Re: The Cottages at Mesa Ridge – Construction Drawings and Final Plat dated August 22, 2022

We are in receipt of your review letter dated September 12, 2022. Below is a point-by-point response to these comments prepared in coordination with the (Developer) and Design Team.

Construction Drawings (El Paso County)

SHEET SAN	10
--------------	----

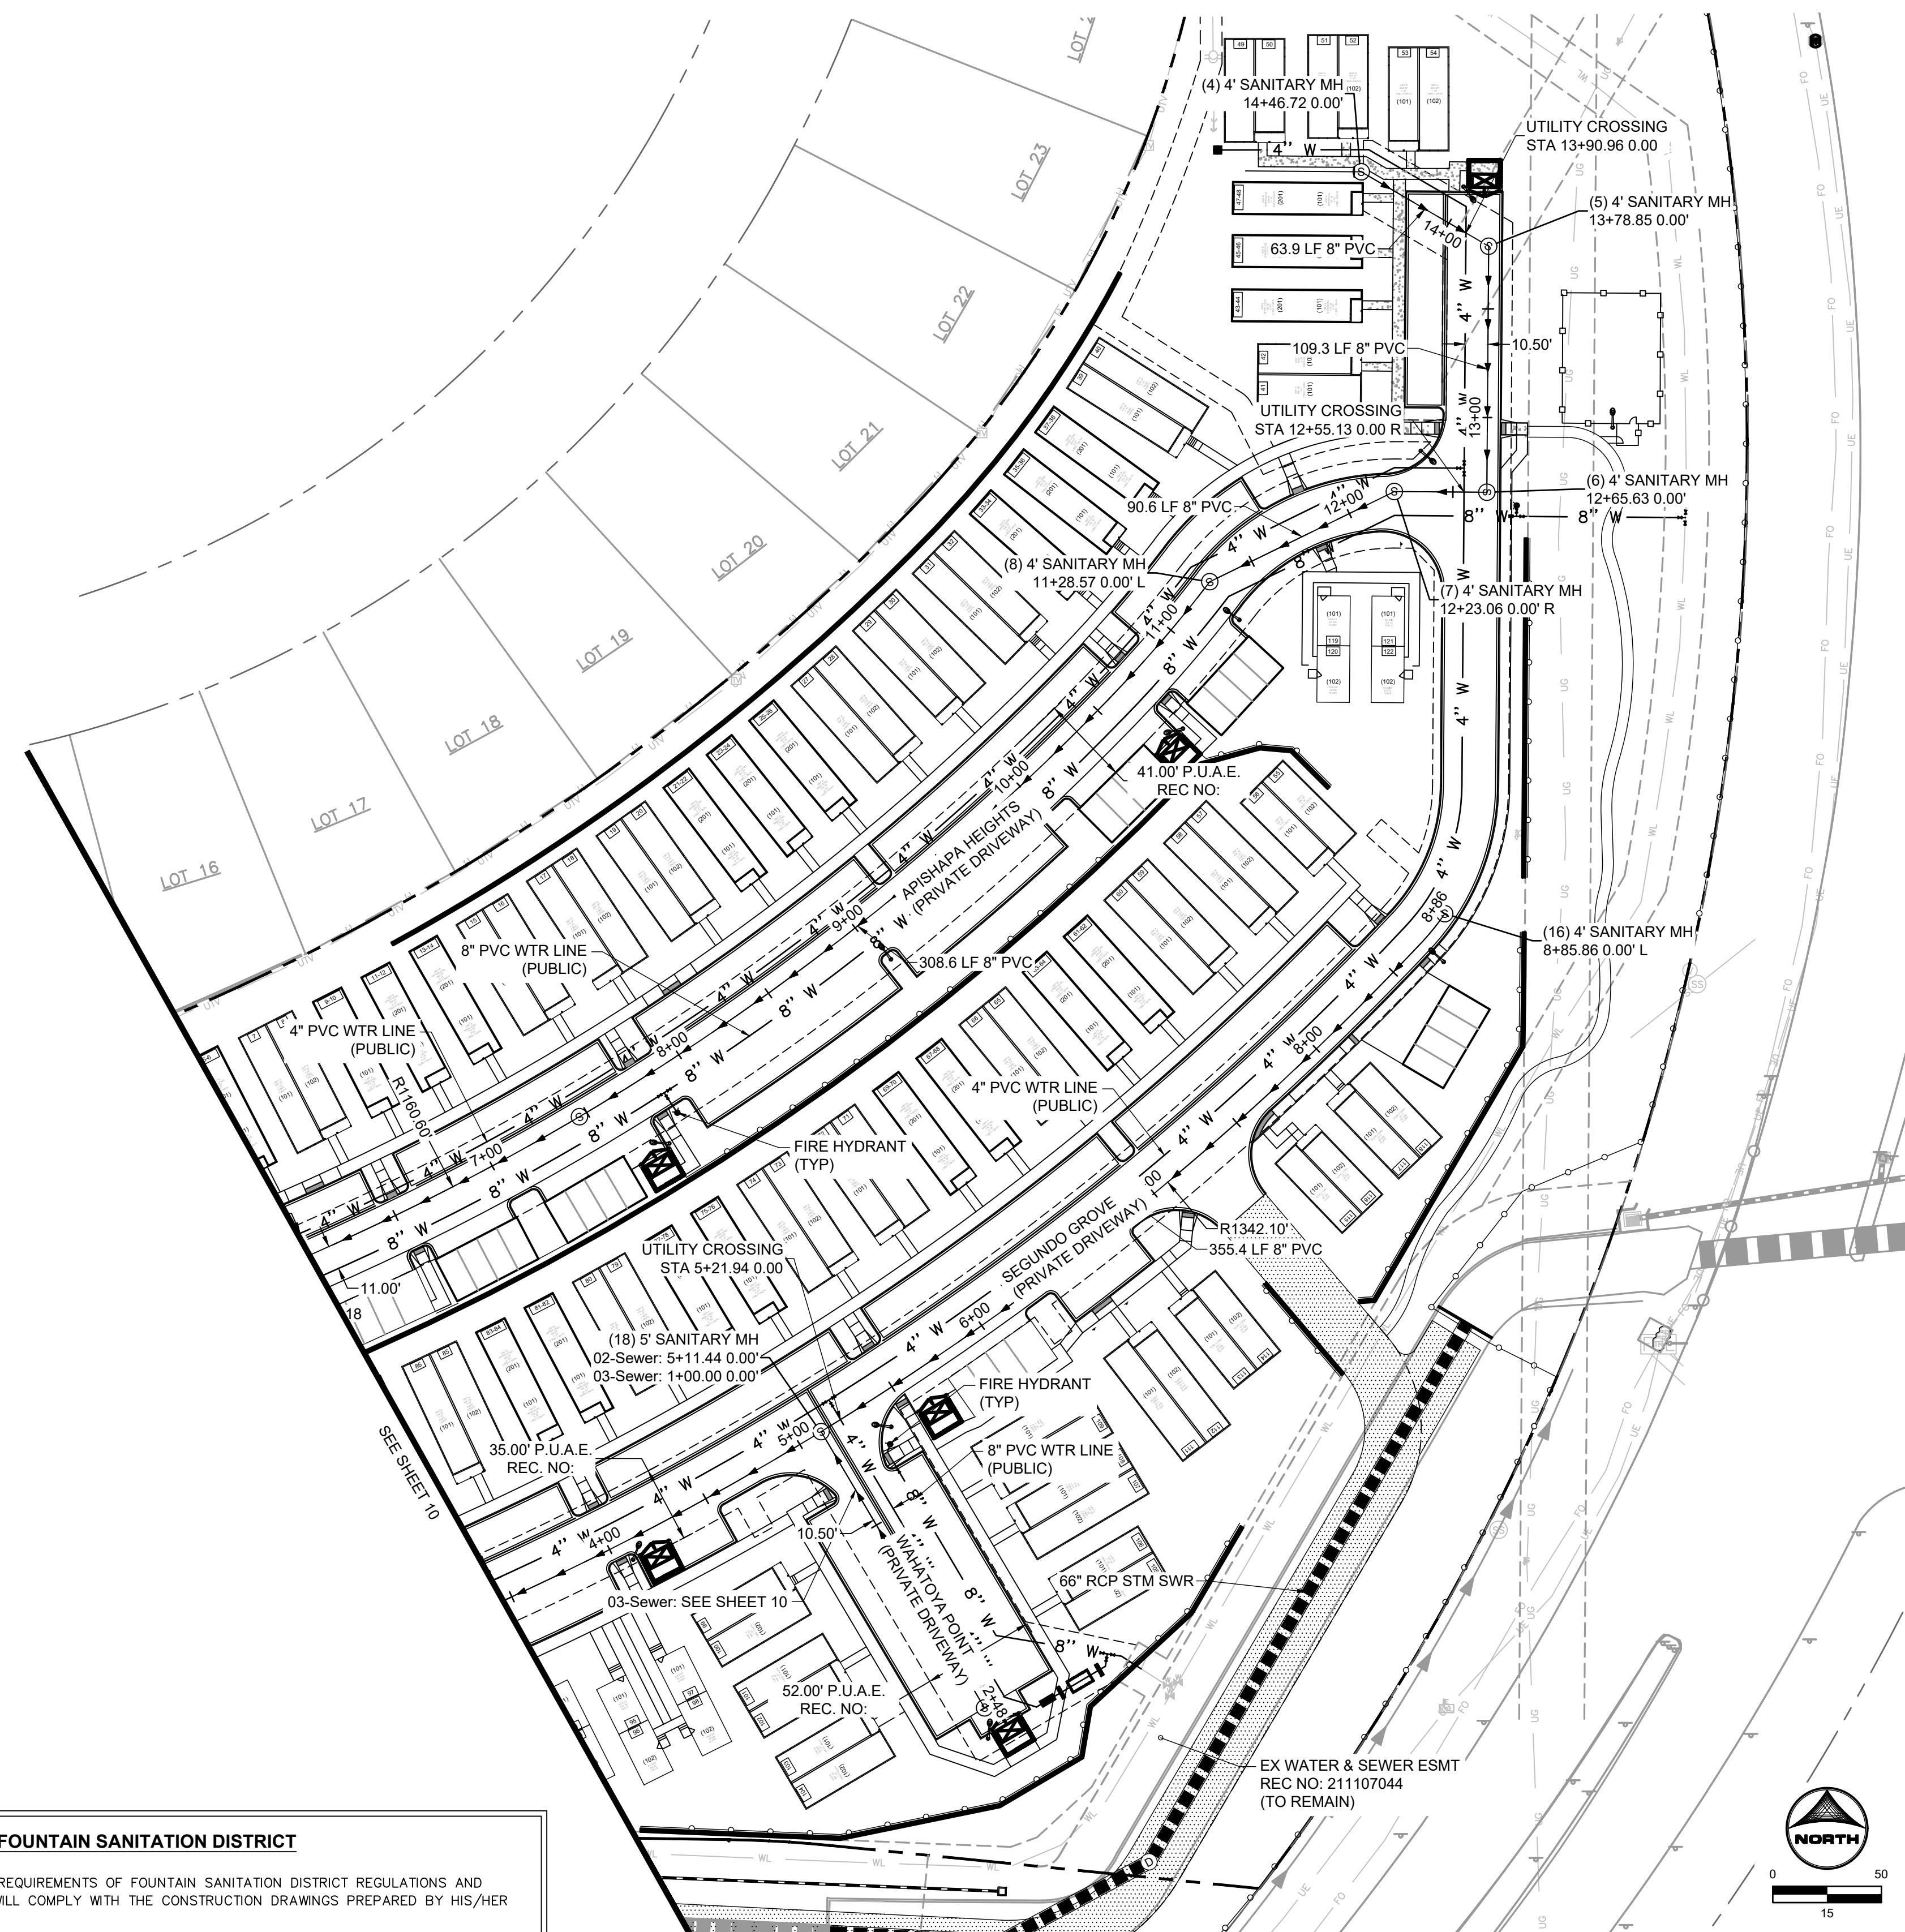
All Sanitary Sewer Design P&P Sheets

1. Add the waterlines in profile view shaded back with minimal labels.

Response: Addressed, see revised profiles.
